3a. Winthorpe Road Active Travel Route (compensatory mitigation required)

3b. Coddington/Beacon Hill NMU route (reducing local motor vehicle use of the SRN)

3c. Active travel route towards Lincoln (reducing local motor vehicle use of the SRN)

A46 Active Travel Partnership Comments

Viewpoint 32: View north-west from PRow Newark BW6 (Bridleway) representative of views for users of the footpath and the River Trent waterway

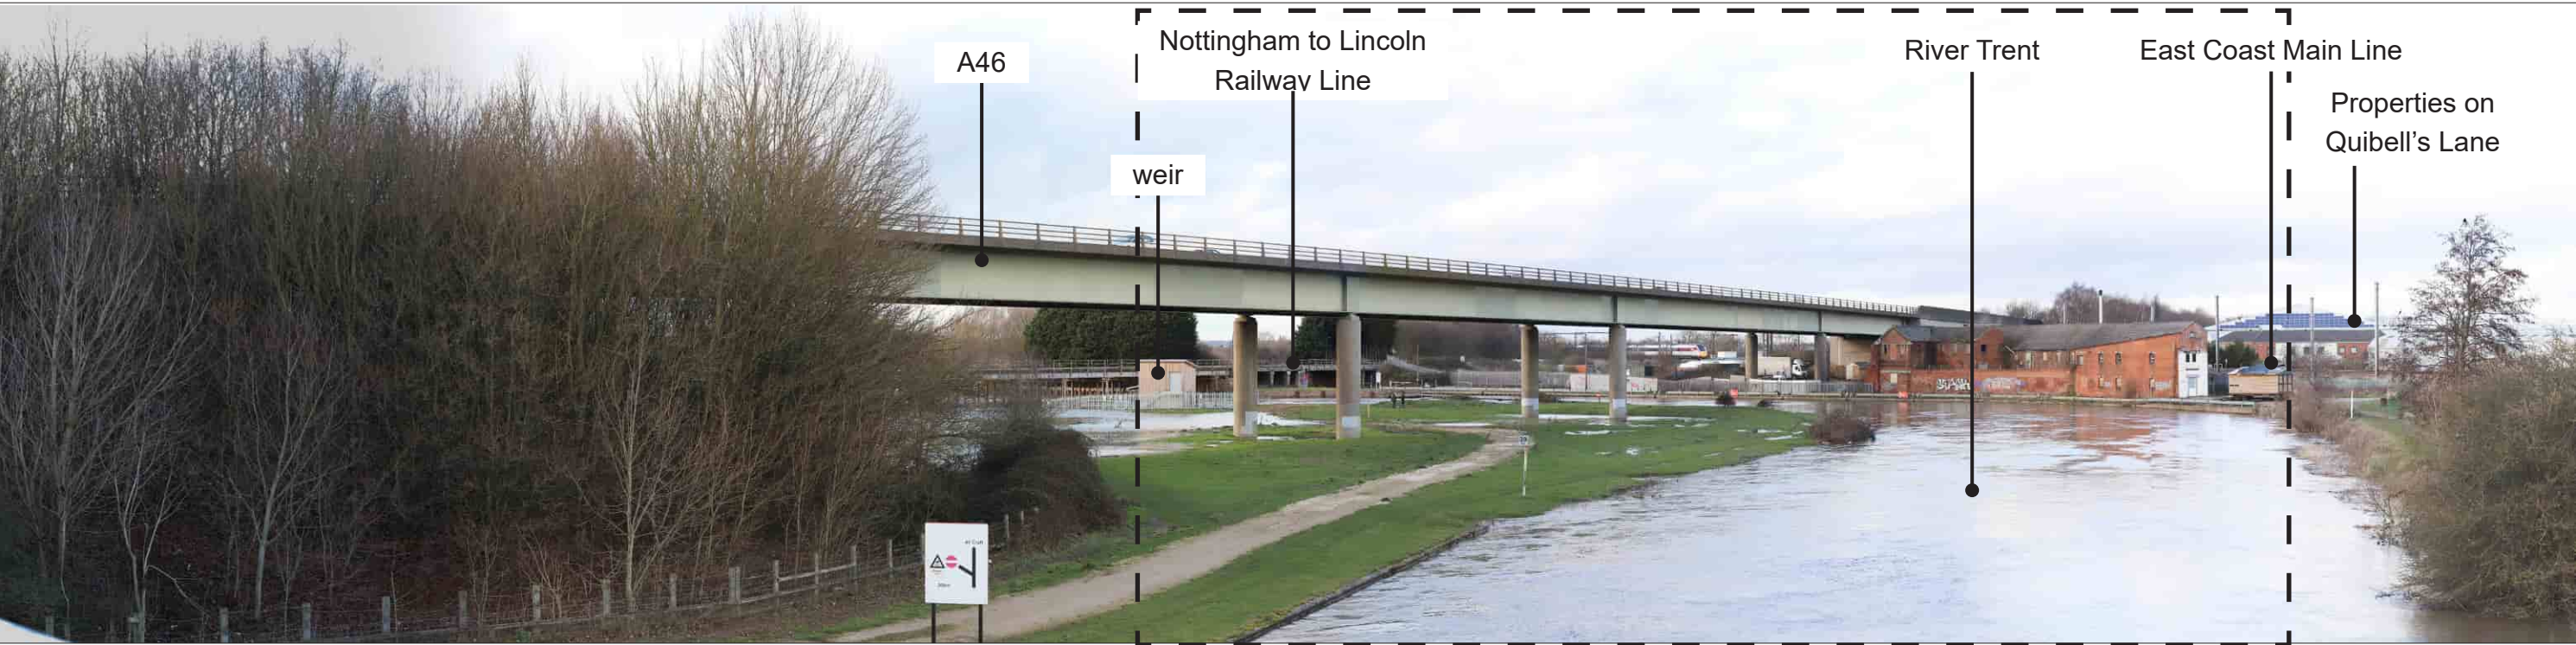
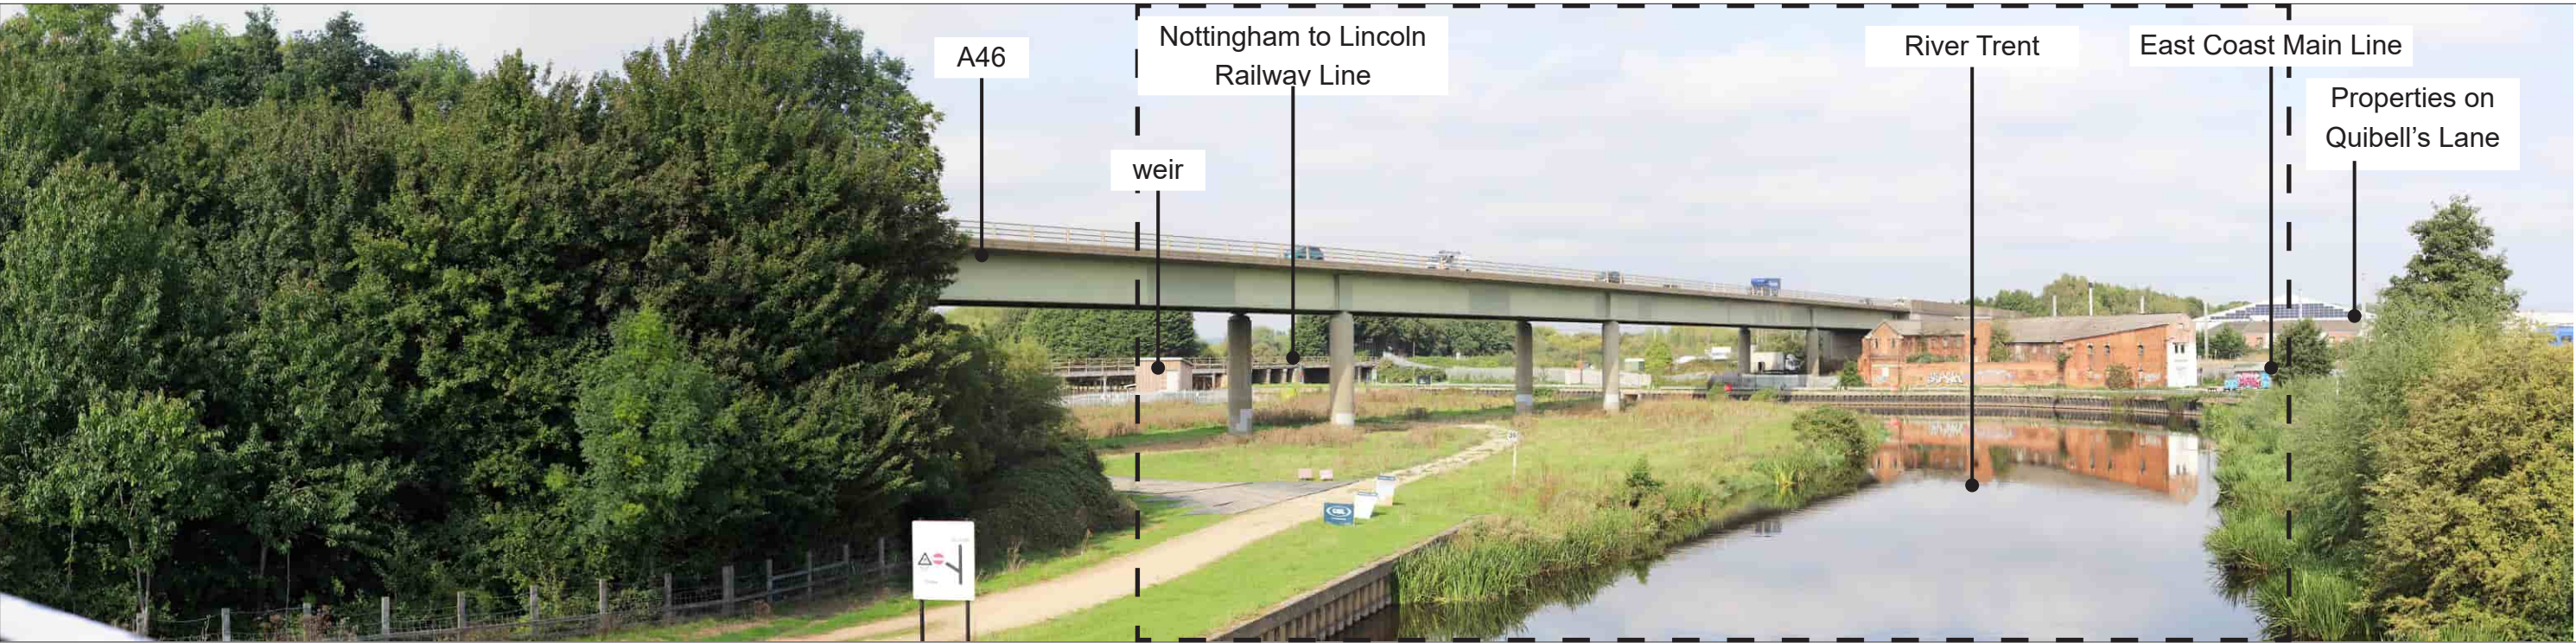
12. This remains a very high priority because of the Trent Valley Way, the long distance footpath which now runs from Staffordshire to Alkborough, Lincolnshire where the Trent meets the Humber and NCN 64. The Trent Vale Trail multi-user route, due for completion in 2025, also follows this route. A group of volunteers (Friends of Trent Vale Trail) have been working hard raising funds and gaining landowner support and have just obtained the funding for the last section at South Clifton. The route will then connect to the Dukeries Trail between Lincoln and Shirebrook, Derbyshire. All three routes would be better passing through the riverside green corridor of an extended bridleway 6.

- compensatory mitigation for the Trent Valley Way, NCR64 and the Trent Vale Multi-user routes currently along Winthorpe Road by extending BW6 alongside the River Trent.
- for recognition of the existing but unregistered Beacon Hill active travel route to the employment sites and wider network as required by NNNPS 2024. Upgrading of the Coddington and Beacon Hill routes was identified in the 2018 scoping of NMU.
- Further information about the D2N2 strategic active travel route towards Lincoln
